MO/RS  
14395  
17 March 2016

## **SUBMISSION ON 80-88 REGENT STREET, REDFERN (SSD 7080)**

We write to you in relation to the public exhibition of the Environmental Impact Statement (EIS) for the abovementioned site on behalf of Iglu Pty Ltd, the owners of the adjoining site to the north at 60-78 Regent Street, Redfern. The NSW Planning Assessment Commission approved an 18-storey student accommodation facility with ground floor commercial/retail spaces on the Iglu site in August 2015 (SSD 6724), for which Iglu are the proponent and future operator. Construction is due to commence on site in the second half of 2016.

1 North Elevation
1:200@A1

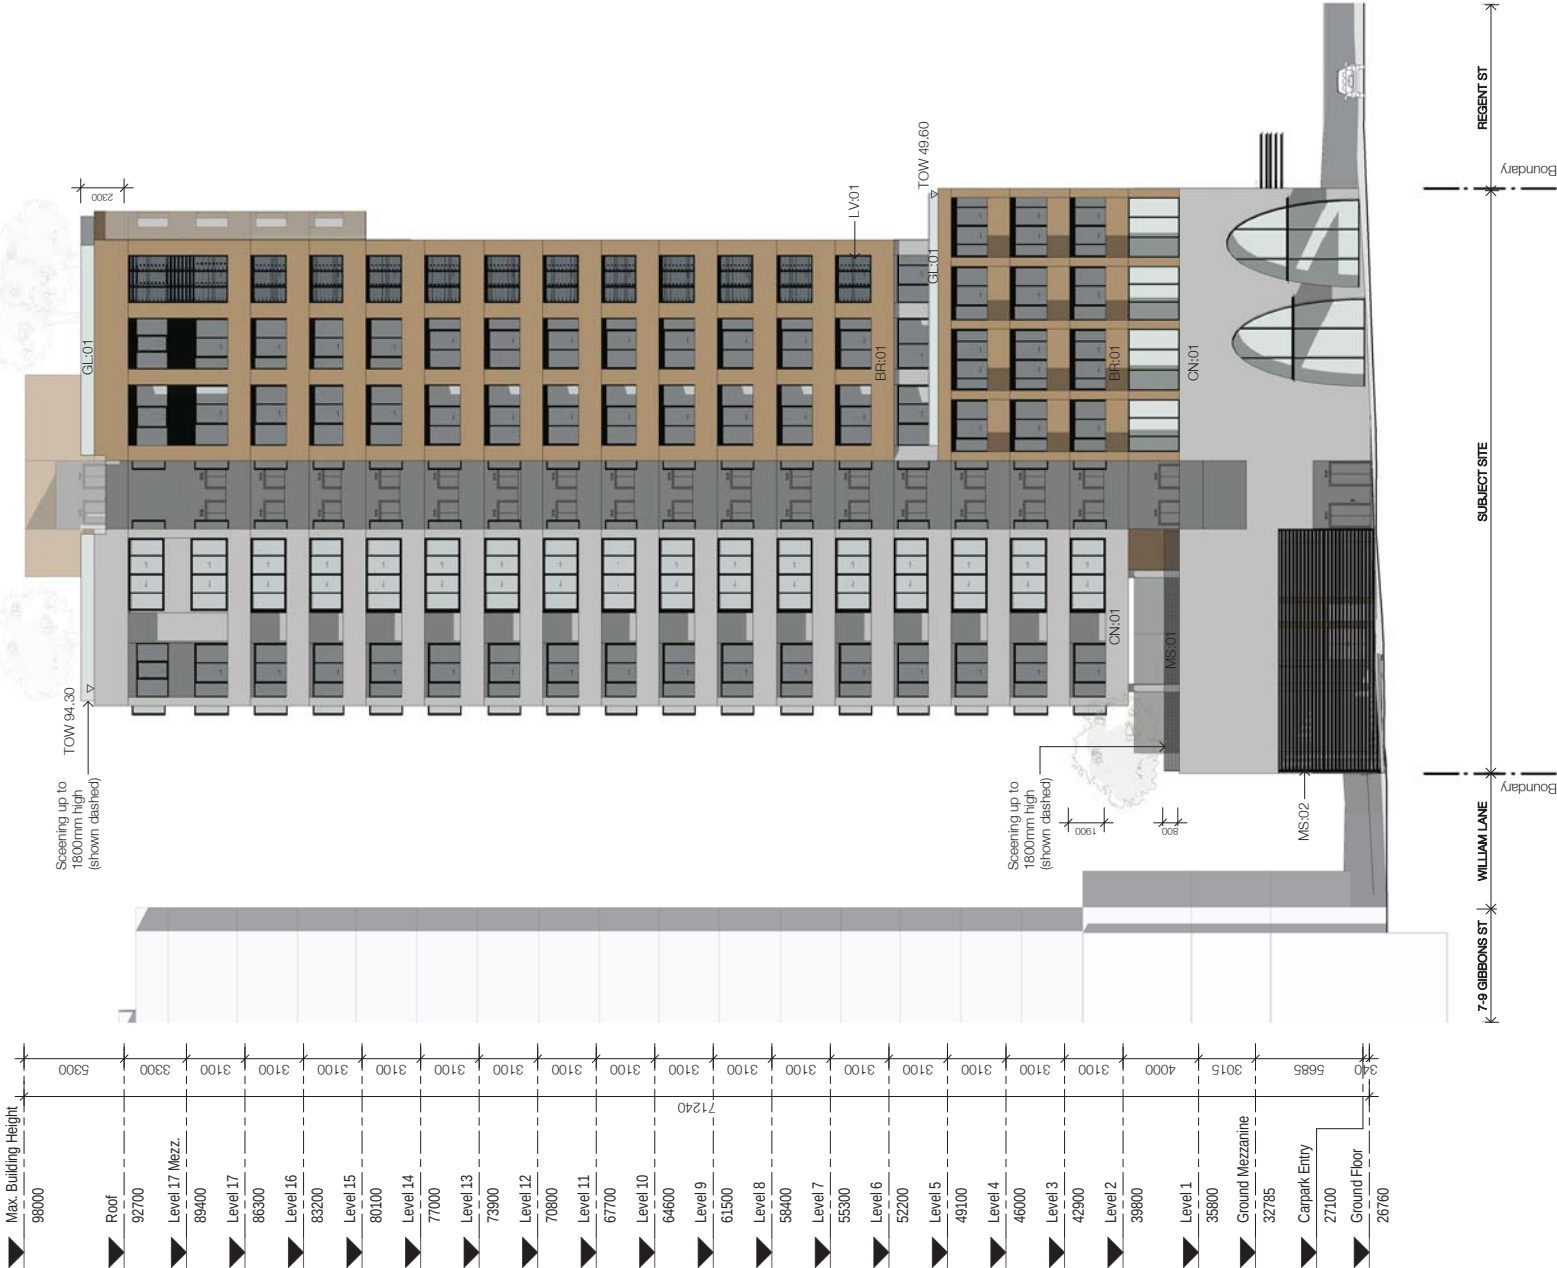
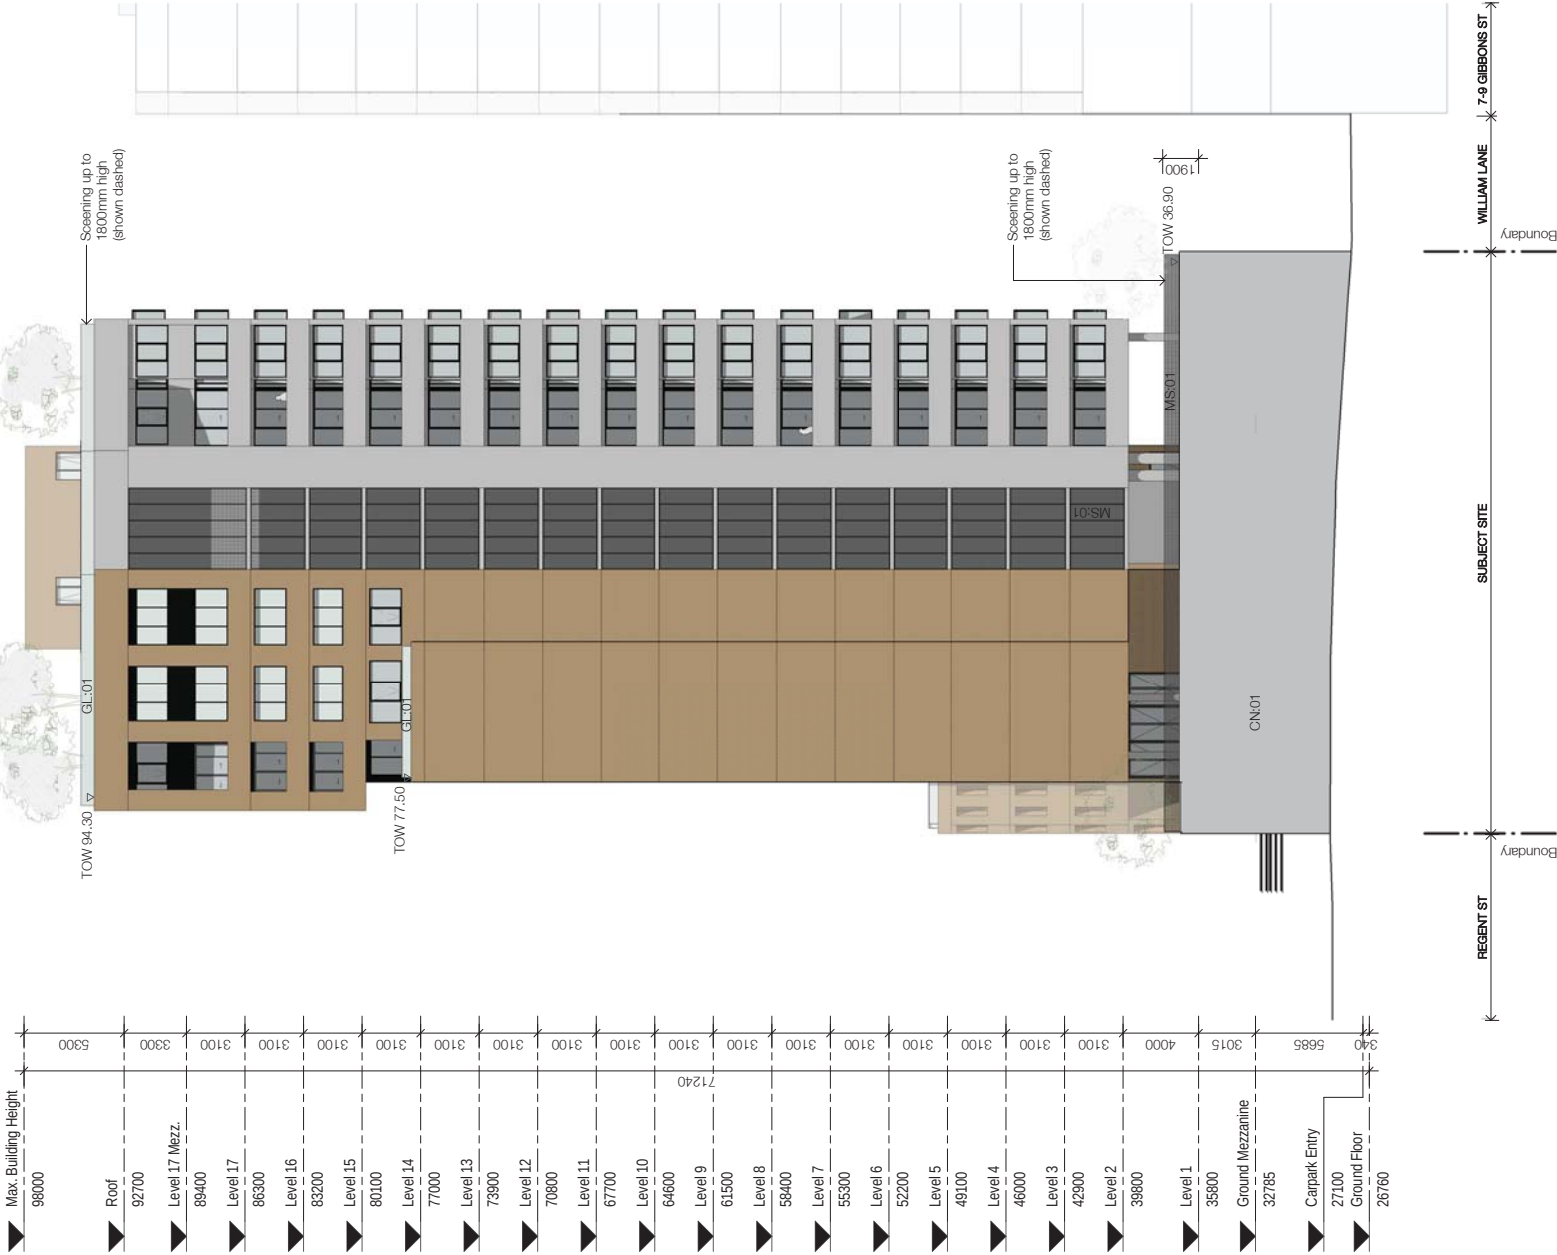
The proposed northern elevation (DA-0502[4]) indicates that north-easterly dwellings on Levels 14-17 (mezzanine) of the proposed building will have open balconies and large bedroom windows facing directly north onto the Iglu site. The proposed balconies and bedroom windows have minimal setback from the common property boundary, and would result in large expanses of

window facing directly toward the upper three levels of the approved Iglu building (as well as views from the proposed building into lower Iglu levels).

The northern windows for the north-eastern apartments in the proposed residential flat building would result in direct visual privacy impacts to student residential amenity across 4-6 levels of the Iglu building, with only 6.6m of separation between the approved Iglu windows and the L14 balcony and 8.1m separation from the L15-16 bedroom windows (Level 17 sits higher than the approved Iglu building). This separation distance is one-quarter to one-third of the minimum distance required under the Apartment Design Guide for building separation between habitable rooms and balconies above nine storeys (24m).

- Consideration to providing an additional physical setback to the common property boundary, in accordance with the Redfern Waterloo Authority 'Urban Design Principles – Redfern Centre';
- Deletion of all north-facing windows and balcony areas for upper level apartments within the north-eastern corner of the proposed building; and/or
- Provision of fixed louvers or window frosting to any north-facing habitable spaces within the proposed building to prevent direct views into the Iglu living spaces.
